**WELWYN HATFIELD BOROUGH COUNCIL
EXECUTIVE DIRECTOR - PLANNING, PUBLIC PROTECTION AND GOVERNANCE**

DELEGATED APPLICATION

Application No: 6/2017/0905/HOUSE
Location: 2 Waterworks Cottages, Northaw Road East, Cuffley, Potters Bar, EN6 4RB
Proposal: Erection of single storey front, side and rear extension, front porch, clipped gable hip roof enlargement, 3x front dormers, 1x rear dormer, 1x side roof light and alterations to openings.
Officer: Mr D Elmore

Recommendation: Refused

12537-P003-E

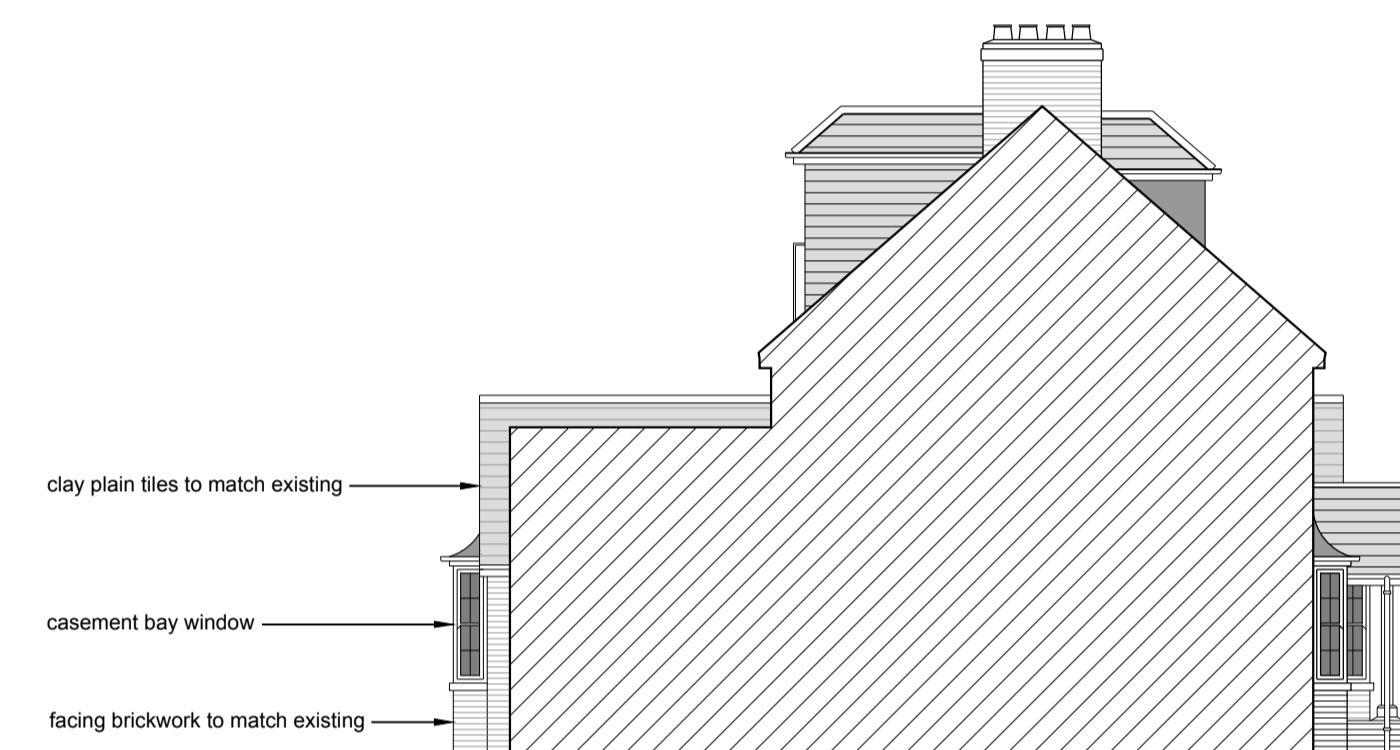
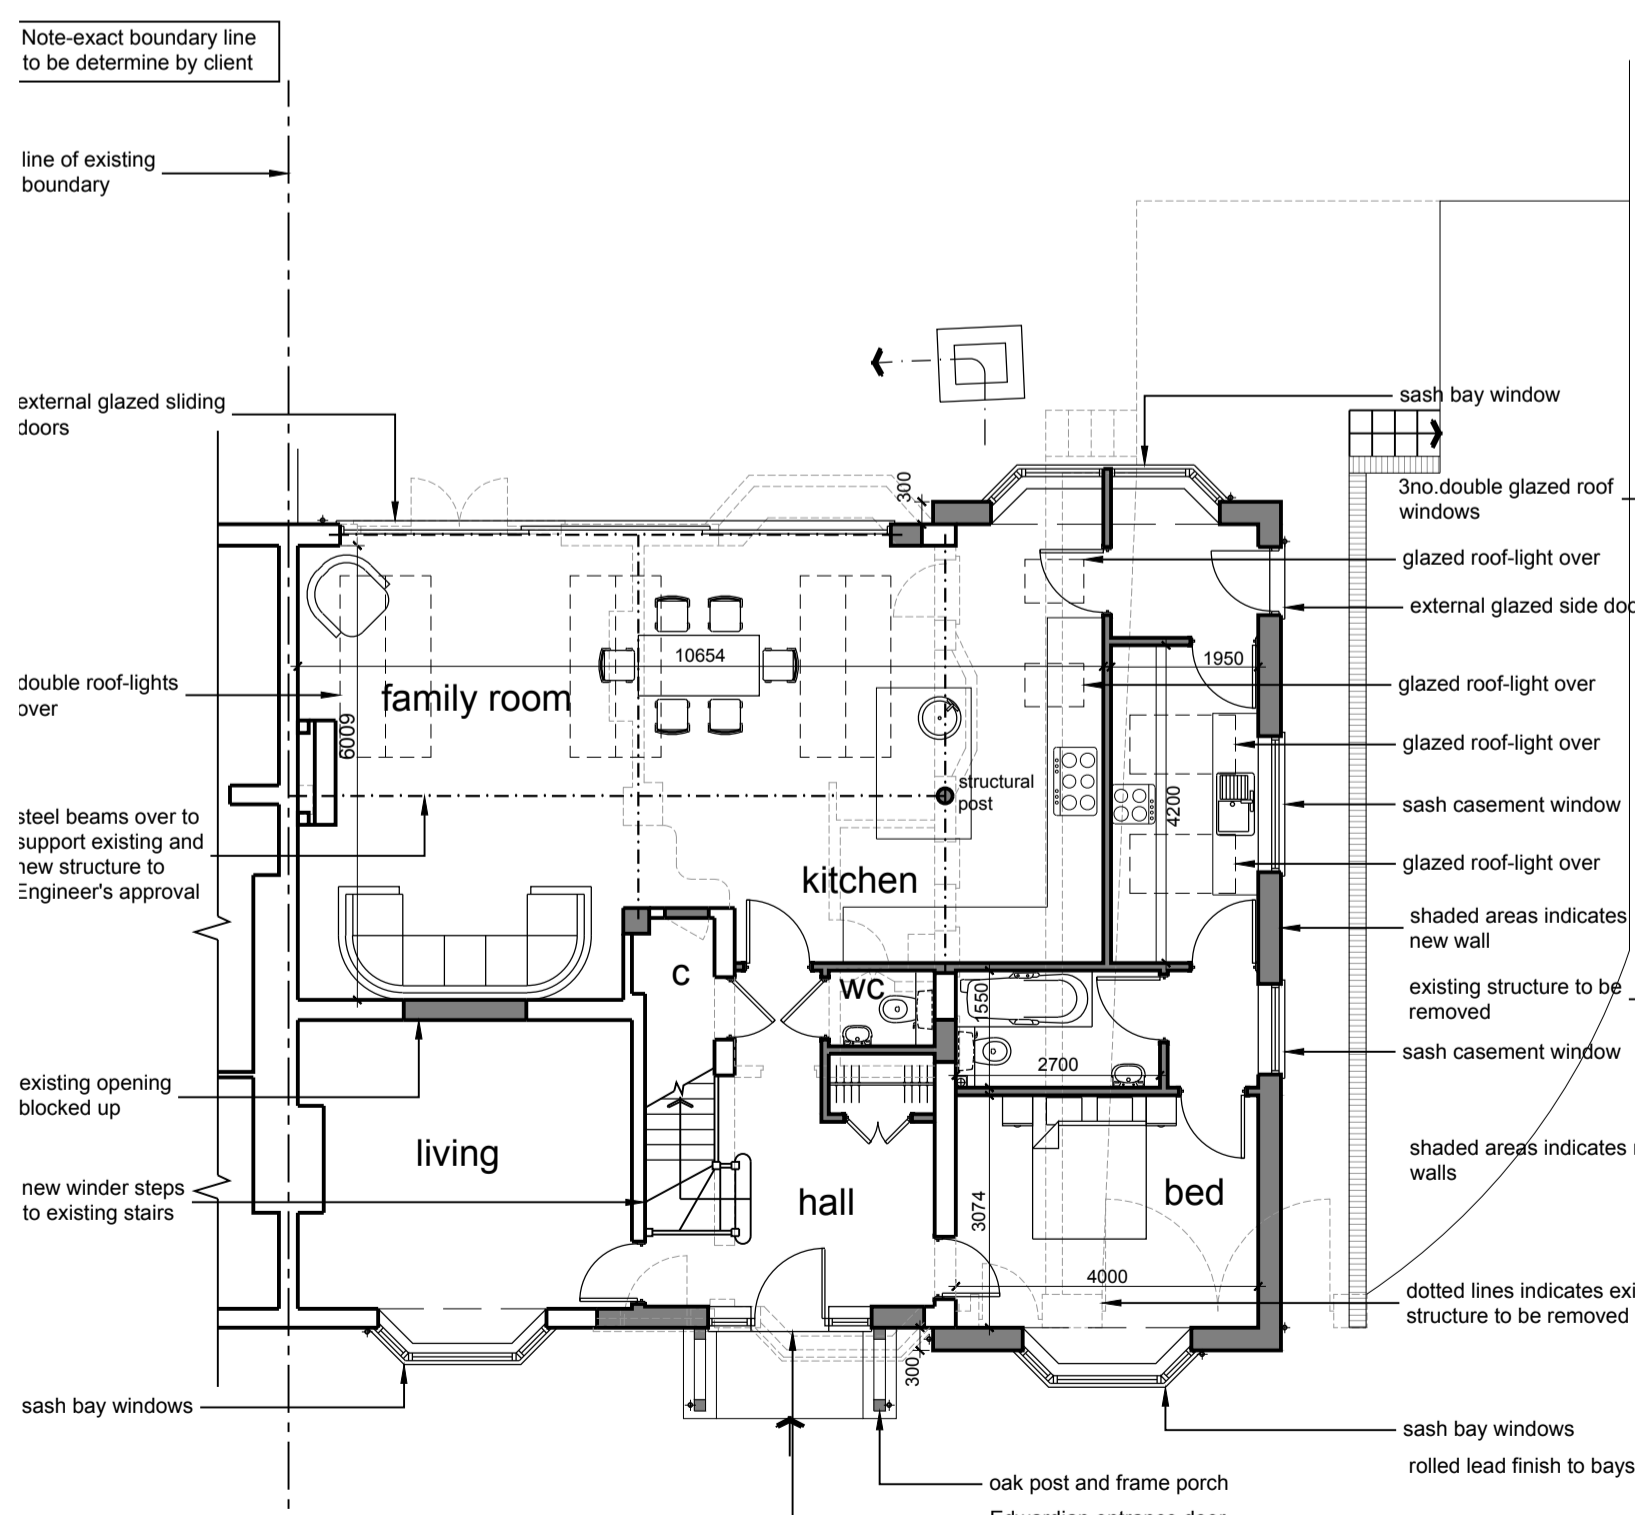
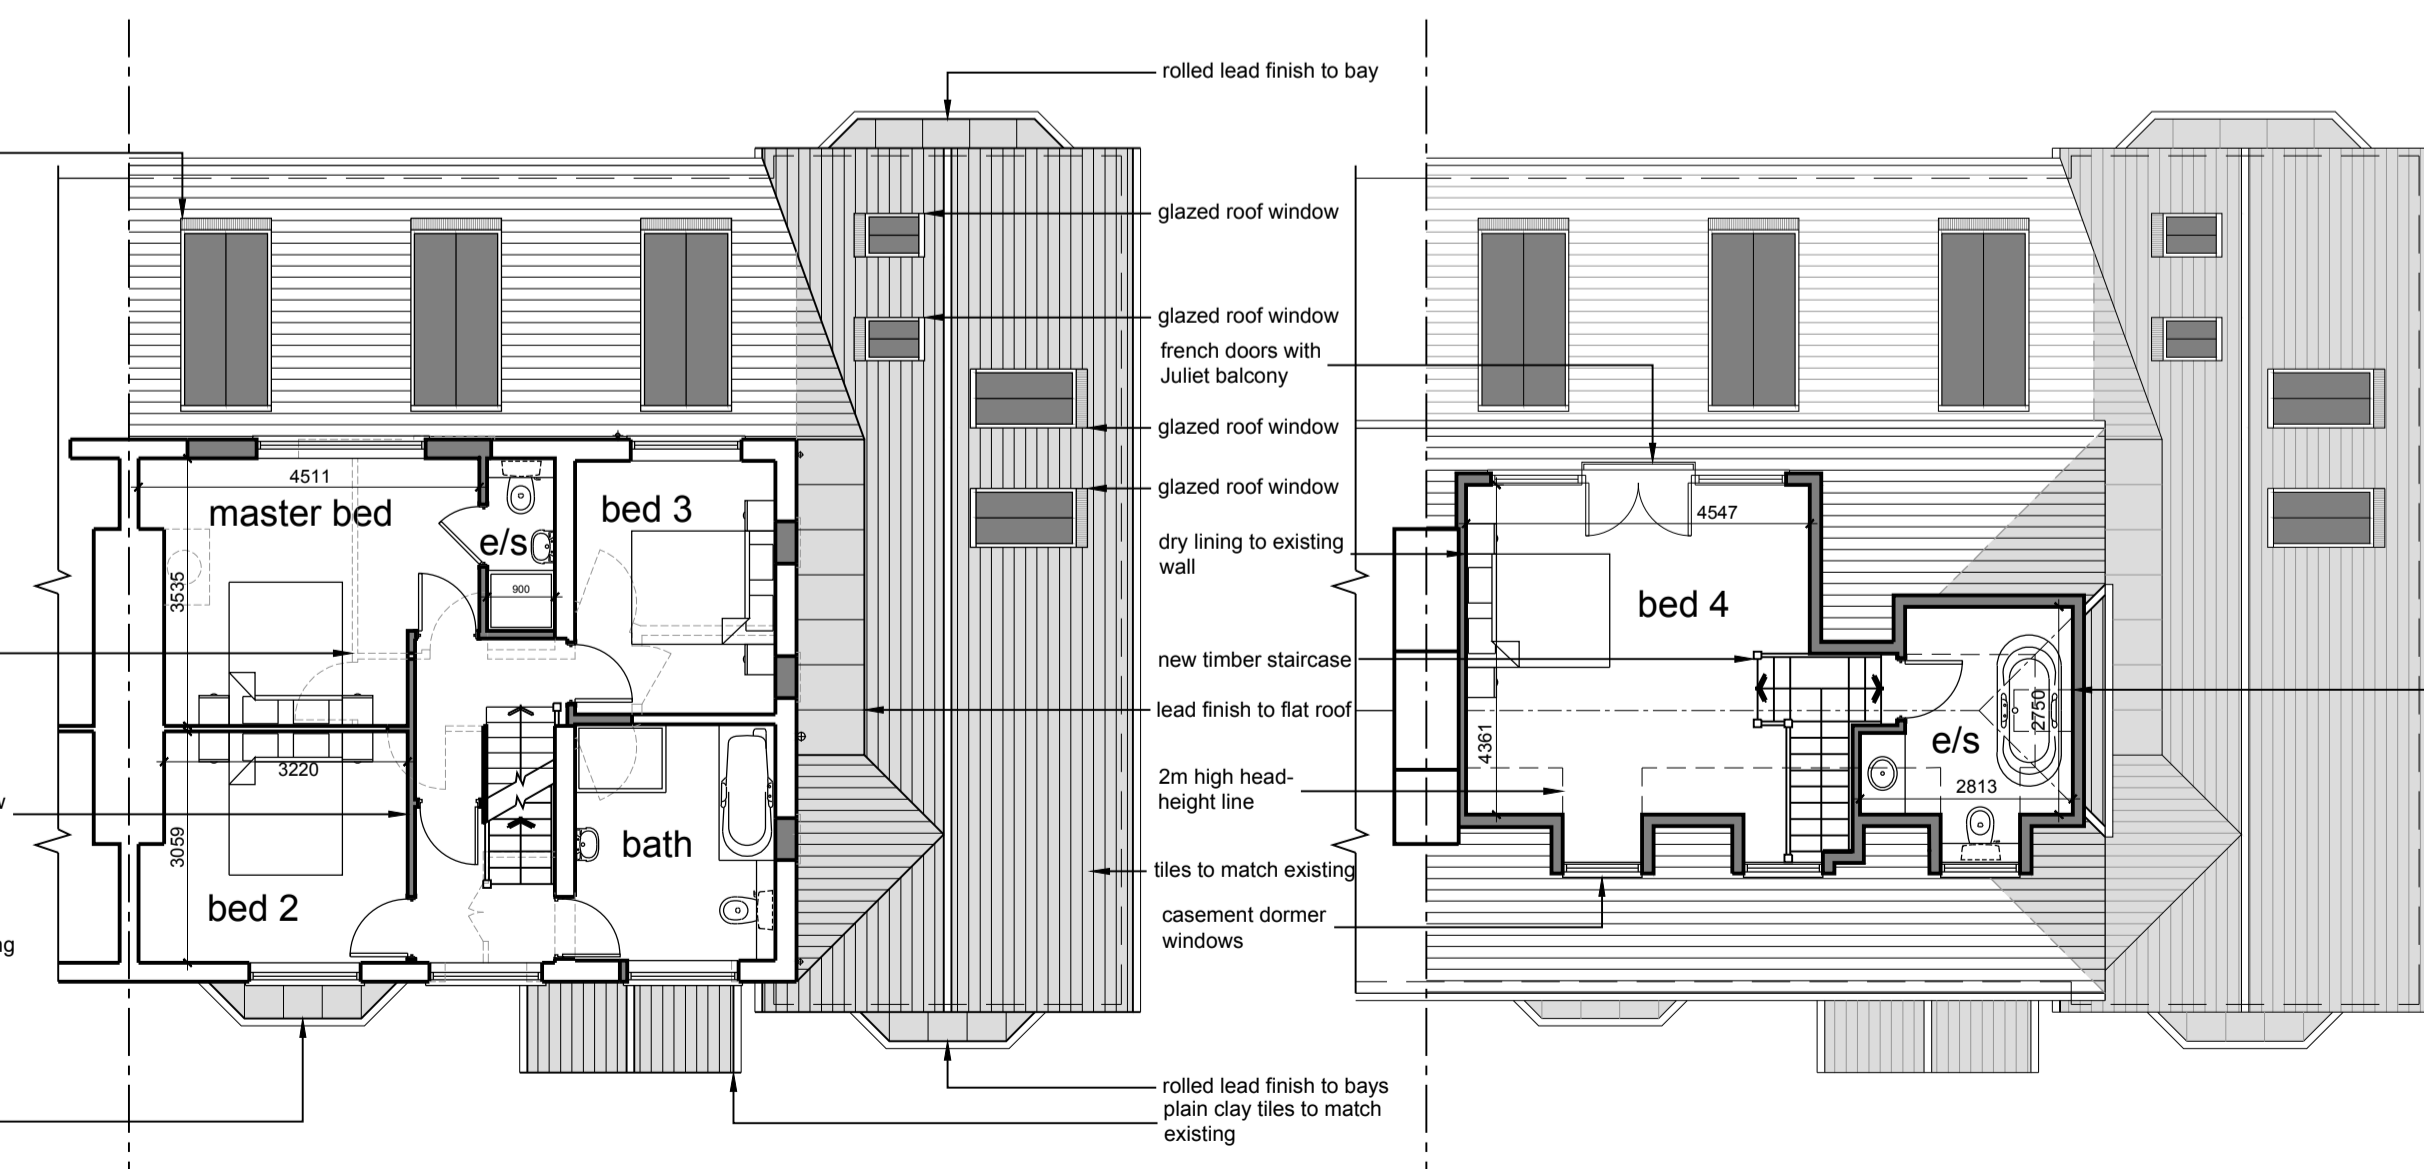
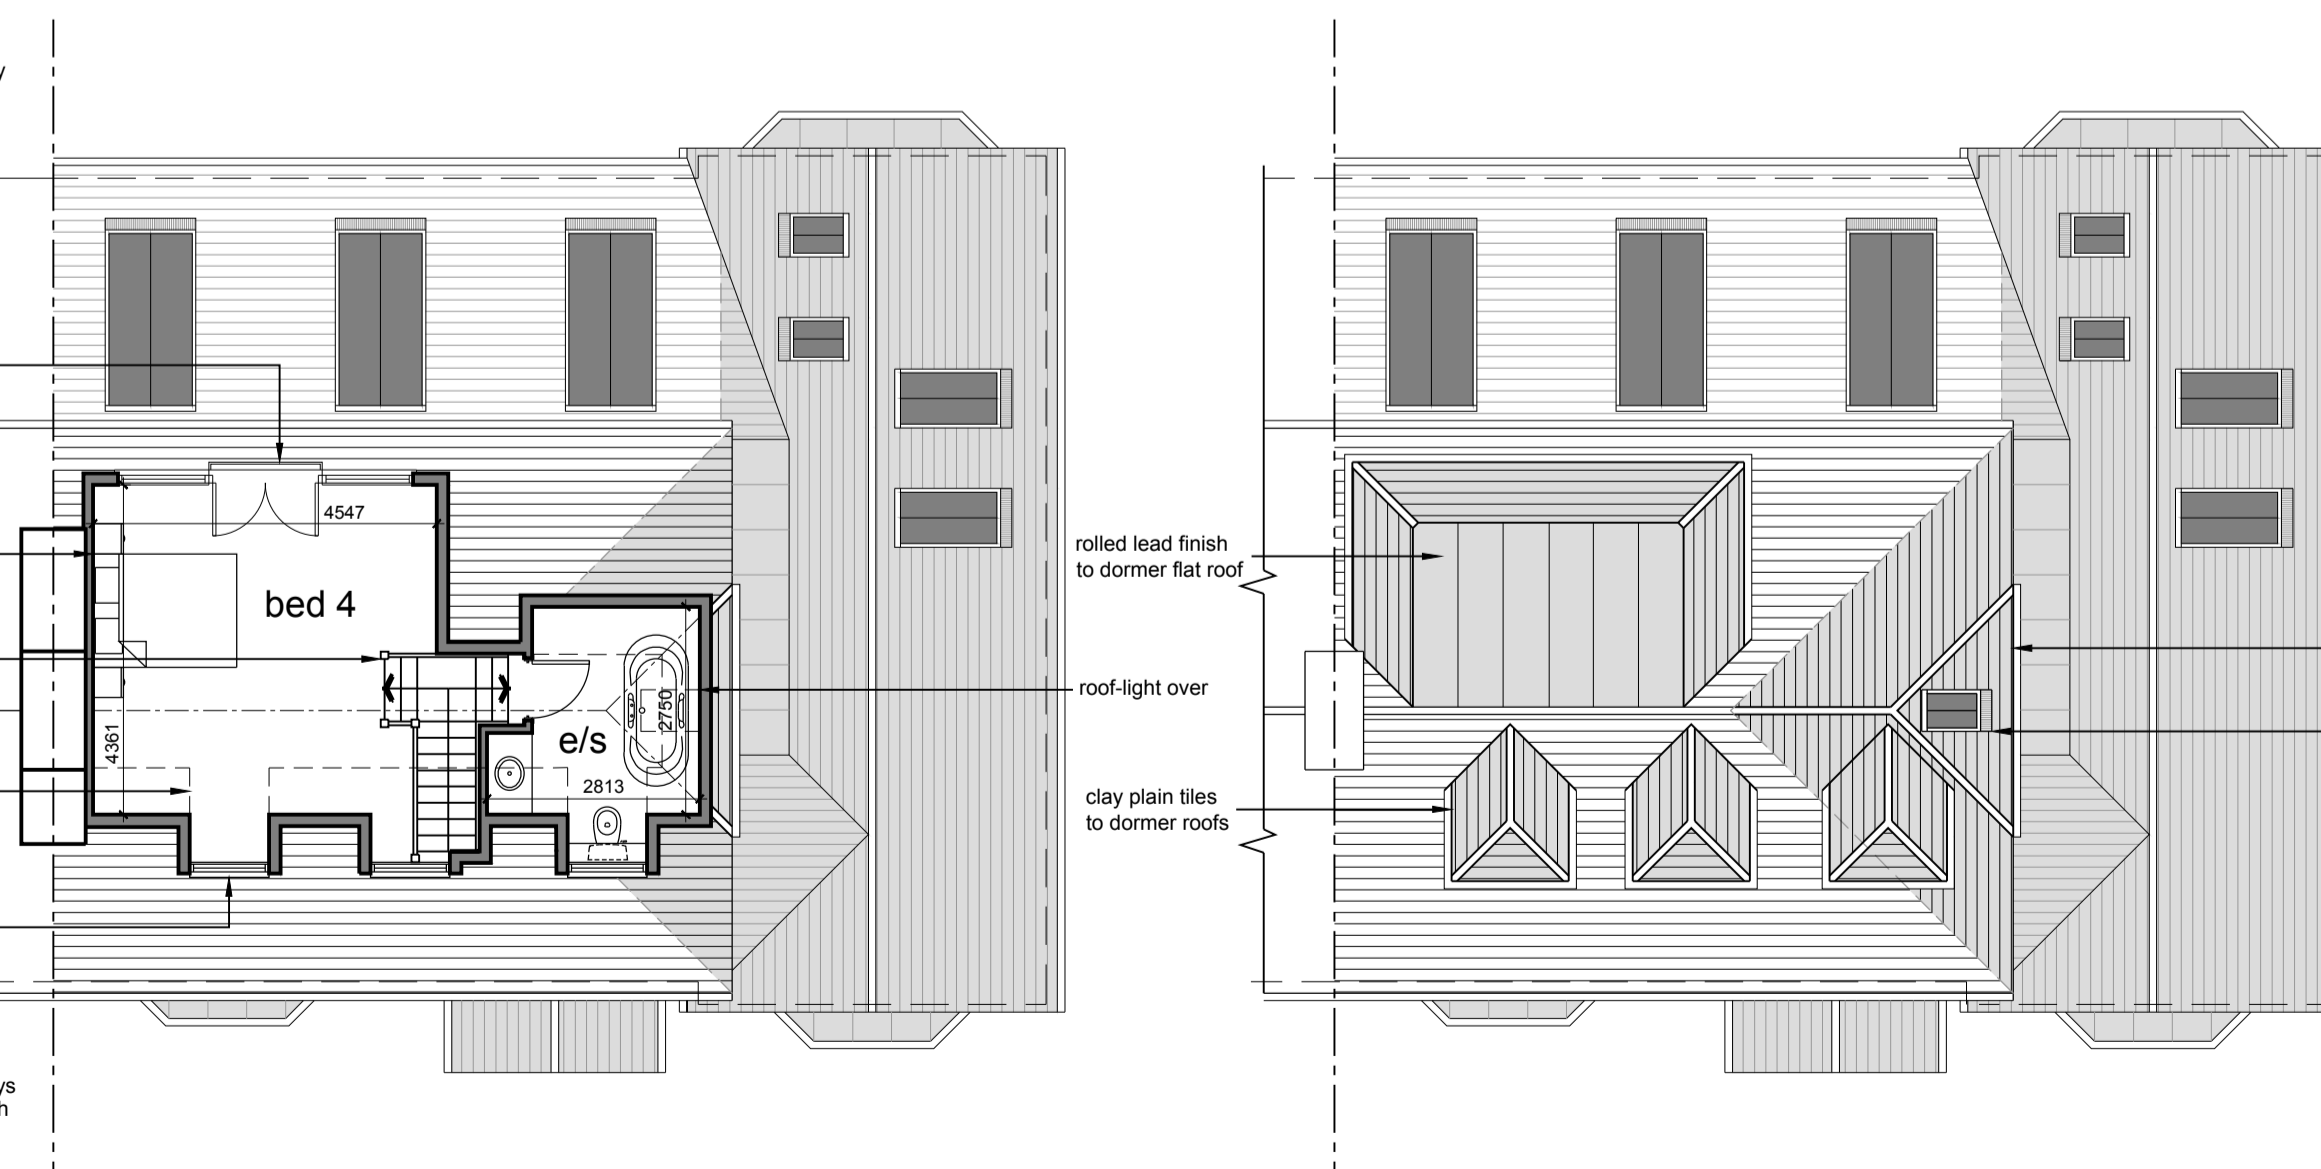
<p>Design (form, size, scale, siting) and Character (appearance</p>	<p>The proposed front, side and rear extension would feature a pitched roof (front and rear gables) and connect to the existing single storey rear extension in a 'wrap-around' effect. The roof connection of this proposed extension to the flank wall of the dwelling and with the mono-pitched roof the existing rear</p>

within the streetscene)	<p>extension would appear awkward and contrived. Furthermore, the use of a front gable ends would fail to complement and reflect the design and character of the existing dwelling.</p> <p>The existing dwelling features a hip-end roof. It is proposed to alter and enlarge this roof to form a clipped gable roof. The original pair of cottages featured hip-ends and No. 1 has altered its roof from hip to gable, including a rear dormer under what appears to be permitted development. The Council however have no record of a lawful development certificate for this property. Considering the gable ended roof of No. 1, the proposed clipped gable roof enlargement would adequately maintain the existing character of the semi-detached pair and is therefore considered acceptable, subject to roof tile matching that of the host property.</p> <p>Now turning to the proposed dormer windows. Section 5, 5.2(vi) of the Council's Supplementary Design Guidance 2005 (Statement of Council Policy 2005) states that "<i>dormer windows should be contained within the roof slope, be subservient to the roof of the property and be in proportion to the existing fenestrations of the property. They must not extend above the ridge height of the existing dwelling and the dormer cheeks should be at least 1 metre from the flank wall of the property or the party wall with the adjoining property.</i>"</p> <p>The proposed rear dormer would only be set in 0.4 metres from the flank wall with the adjoining property and therefore fails to meet the minimum 1 metre set in distance as stipulated above. Furthermore, this rear dormer, by virtue of its width and height, would dominate the resultant roof slope. Accordingly, this element of the proposal would represent a poor standard of design.</p> <p>Notwithstanding the unacceptability of the rear dormer, the proposed front dormers are modest in their scale, in proportion to the existing fenestrations of the property and their pitched roofs would complement the principal roof form.</p> <p>The proposed front porch would be subordinate in scale to the host dwelling and has a limited depth so as to ensure that it is not prominent.</p>

The proposed rear dormer, by virtue of its width and height, would fail to be subservient to the roof of the property and, given its positioning on the roof slope, would fail to provide effective relief from the party wall with the adjoining property. Accordingly, this element of the proposal represents a poor standard of design, contrary to Policy D1 of the Welwyn Hatfield District Plan 2005, Supplementary Design Guidance 2005 (Statement of Council Policy) and National Planning Policy Framework 2012.

1. The proposed development results in disproportionate additions over and above the size of the original building and therefore represents inappropriate development within the Green Belt. Furthermore, the increased bulk, footprint and massing of the proposed development would result in a loss of openness and visual permeability of the Green Belt. Very special circumstances do not exist. Accordingly, the proposal is contrary to Policy GBSP1, GBSP2 and RA3 of the Welwyn Hatfield District Plan 2005 and National Planning Policy Framework 2012.

2. The roof design of the proposed front, side and rear extension would connect to the existing flank wall and single storey rear element in an awkward and contrived manner. Furthermore, the use of a pitched roof with front gable would fail to be in keeping with the design and character of the existing dwelling. As such, this element of the proposal would represent a poor standard of design which would fail to complement and reflect the design and character of the existing dwelling, contrary to Policy D1 of the Welwyn Hatfield District Plan 2005, Supplementary Design Guidance 2005 (Statement of Council Policy 2005) and National Planning Policy Framework 2012.

3. The proposed rear dormer, by virtue of its width and height, would fail to be subservient to the roof of the property and, given its positioning on the roof slope, would fail to provide effective relief from the party wall with the adjoining property. Accordingly, this element of the proposal represents a poor standard of design, contrary to Policy D1 of the Welwyn Hatfield District Plan 2005, Supplementary Design Guidance 2005 (Statement of Council Policy 2005) and National Planning Policy Framework 2012.
